Address: 74 Lingards Road Huddersfield HD7 5HY

| Application number: 2020/93954   |                                                            |
| What is the application for?:    | Erection of 43 dwellings and associated works              |

| Type of comment: An objection

House Type A1.

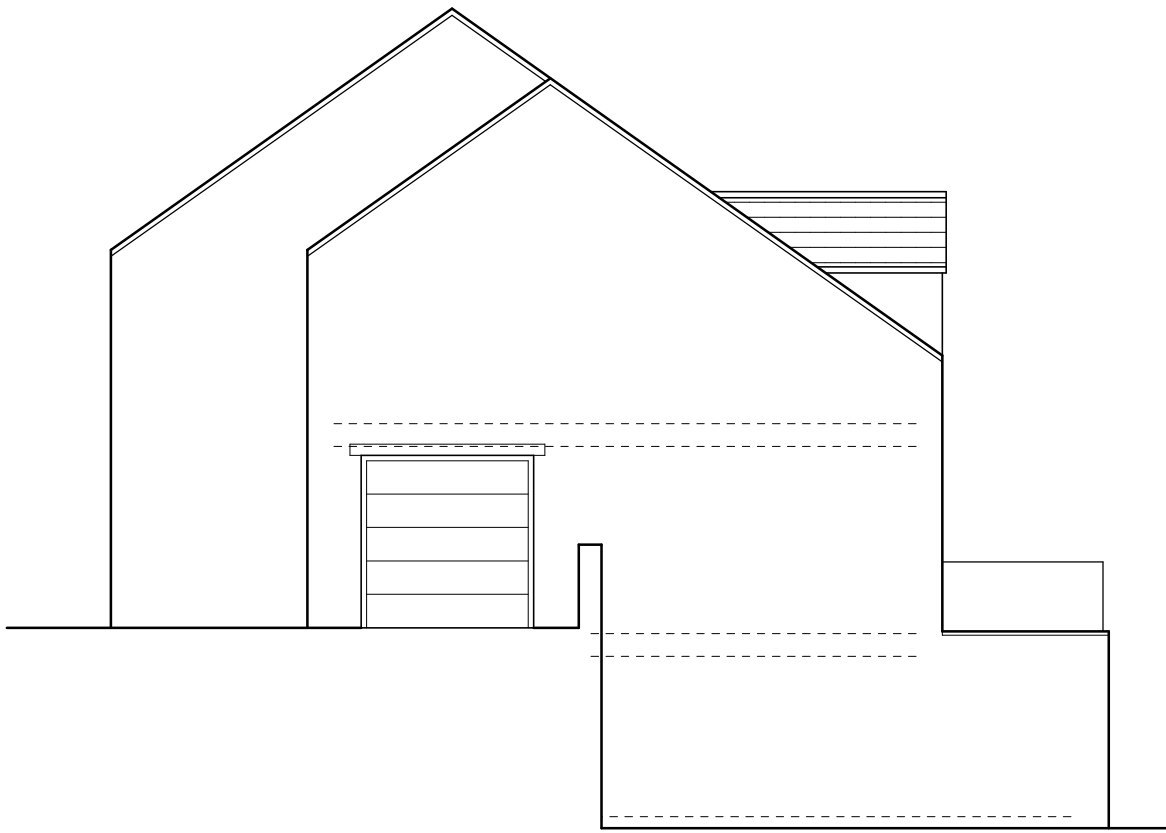
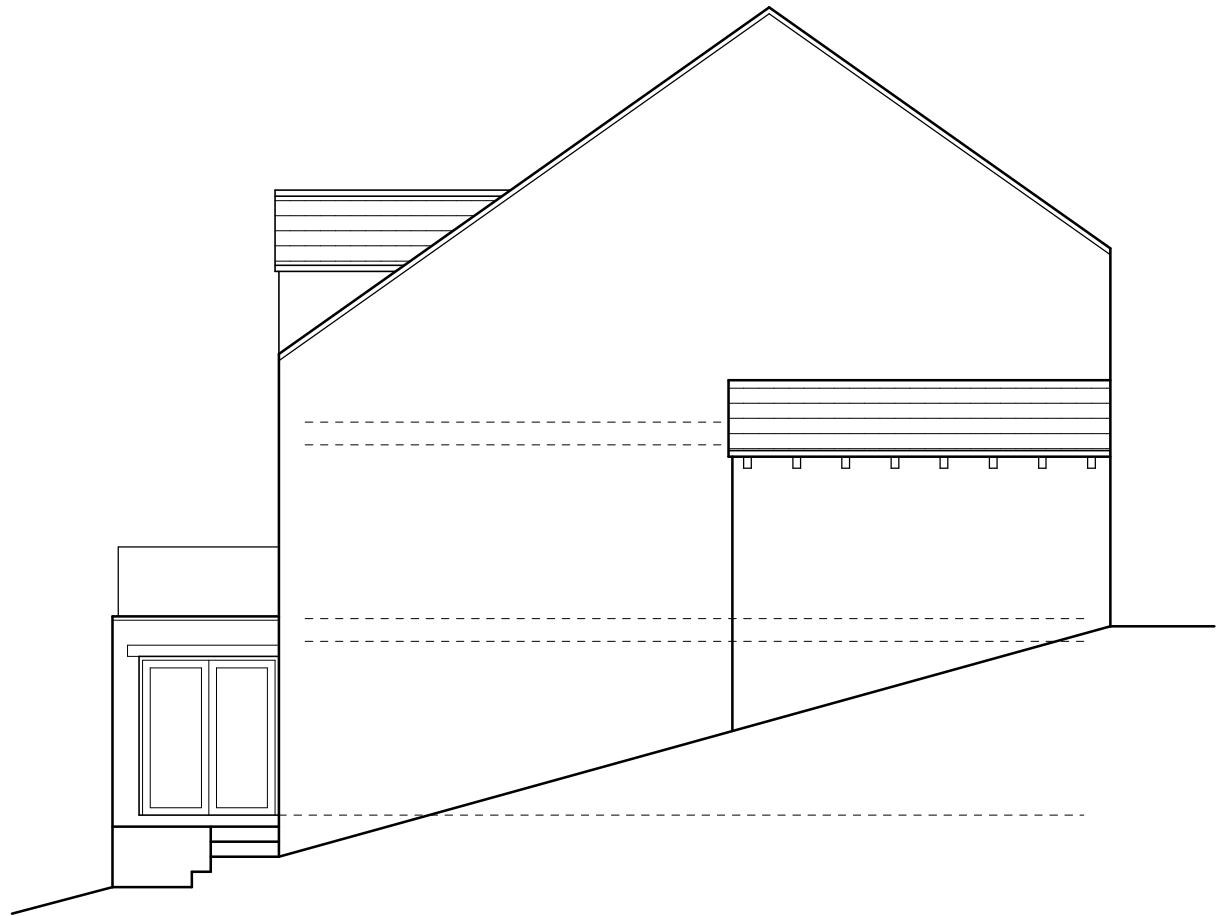
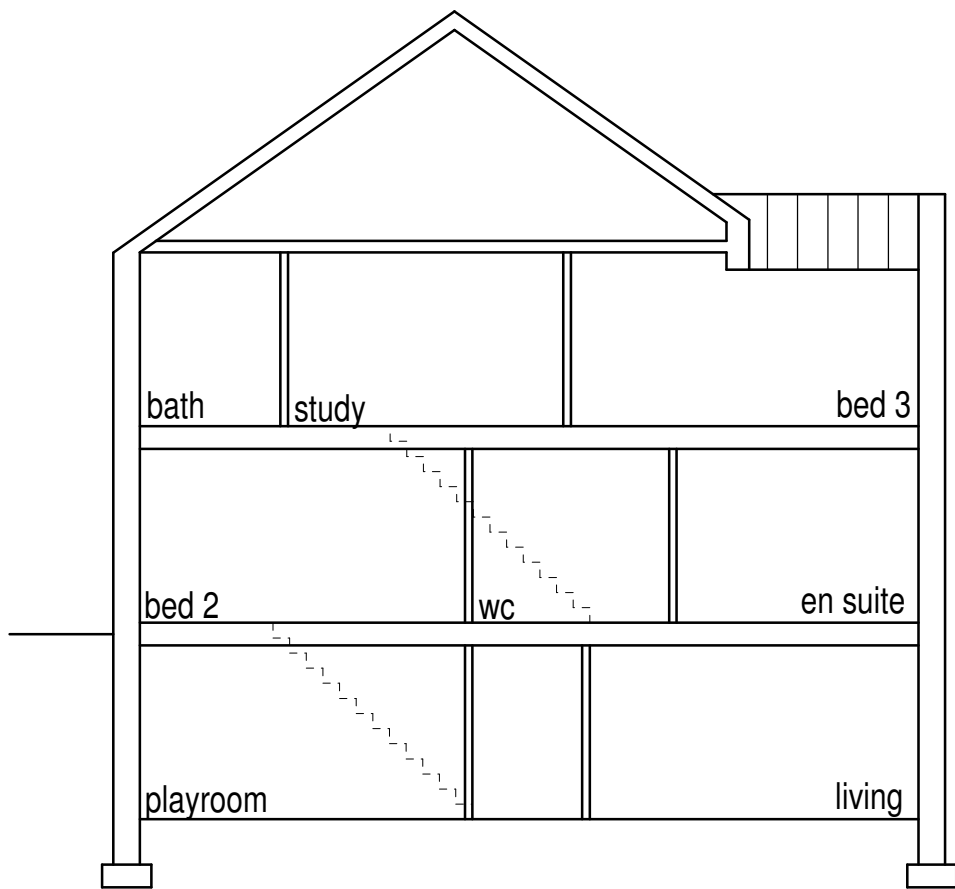
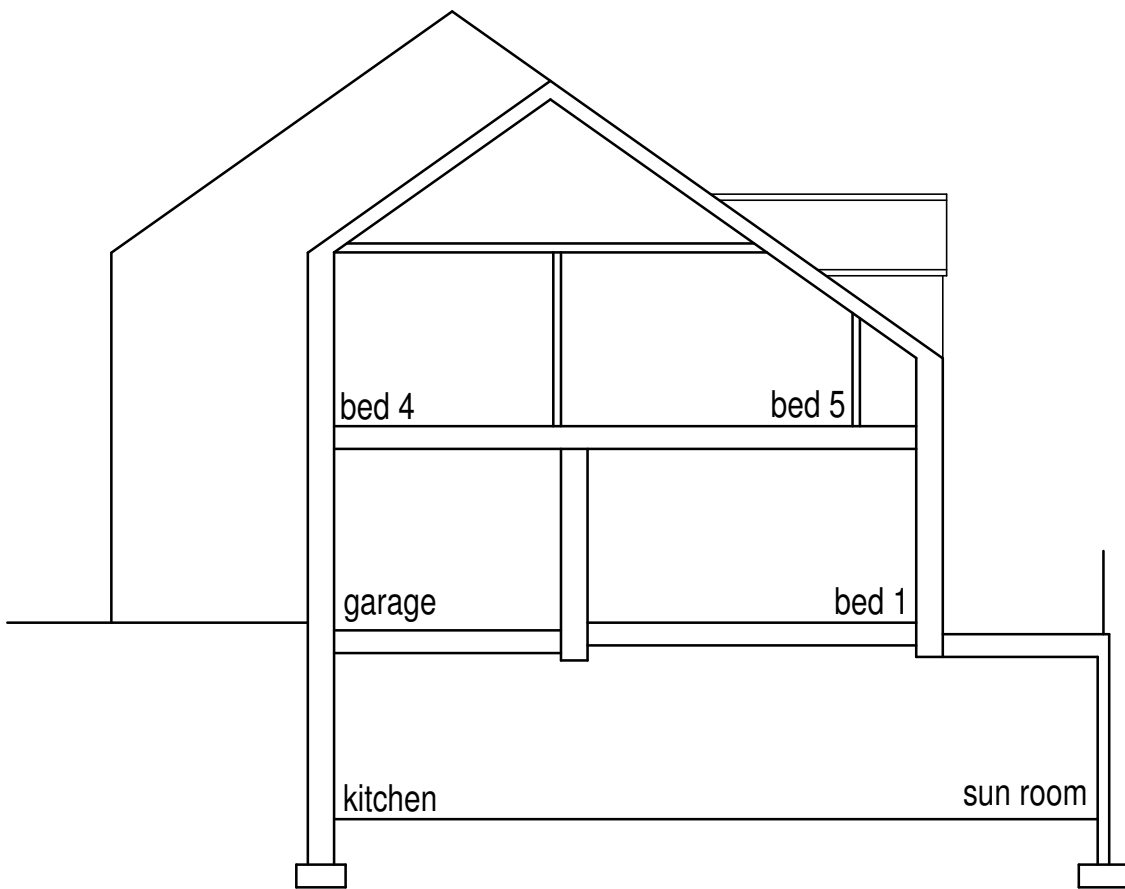
| <p>We object to the current plans on the following grounds:<br/>Again, why is it necessary to have 3 storey houses!. The height of the houses adjacent to Lingards Road will totally overlook the existing houses and will take away all our light and privacy. They are out of character of the existing landscape and dwellings surrounding it. The original plans for 27, 2 storey dwellings would be much more in keeping. Nobody has ever explained why this has changed.</p> <p>The Driveways directly on Lingards Road are dangerous and a hazard. So too is the increased traffic up and down Lingards, which is not built for this amount of traffic.</p> <p>We are concerned that there is not enough parking spaces for 3-5 bedroom houses which will result in cars being parked on Lingards Road, cluttering the already very narrow road.</p> <p>The main access to the development is on Lingards Road. This is an already busy road and wasn't built for this amount of traffic and would be better off with an access point directly from Manchester Road.</p> <p>Is no-one reading the detail of these objections as the plans don't seem to be addressing many of the points raised, other than a few extra trees and grass verges? We accept that the land will be built on, but surely we need to retain the beautiful character and rural aspect of the area. Once the plans are passed it will be too late. Lets get this right now!</p> |    |
